Front Range Midway Solar Project

Haul Route Map

El Paso County, Colorado

CORE Project #: 17-012 Date: 1/18/2018

Haul Route Map

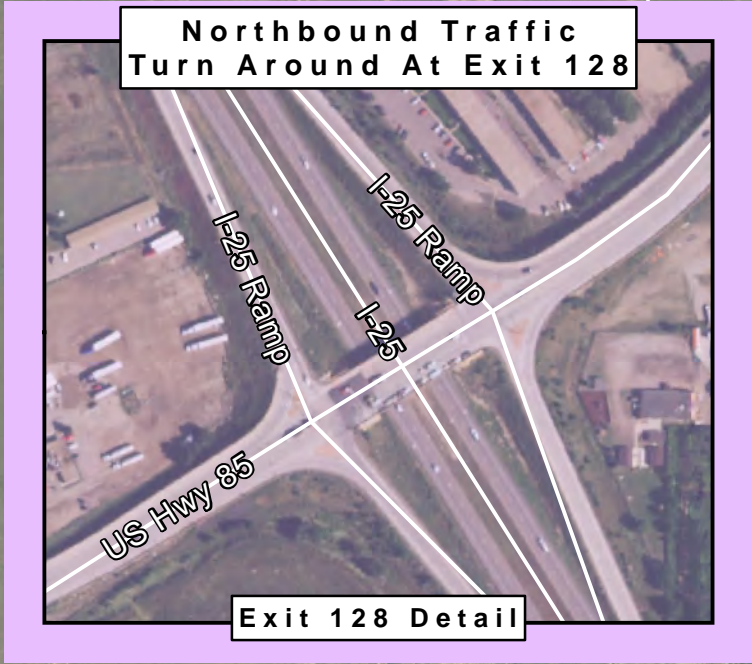
Add pink Private haul route to this section thru the private road your constructing off of La Questa

do you not plan on going past this point with the heavy trucks?

All access shown to come off a public road must be delineated and called out as temporary (for construction) or permanent. A County access permit will be required for either.
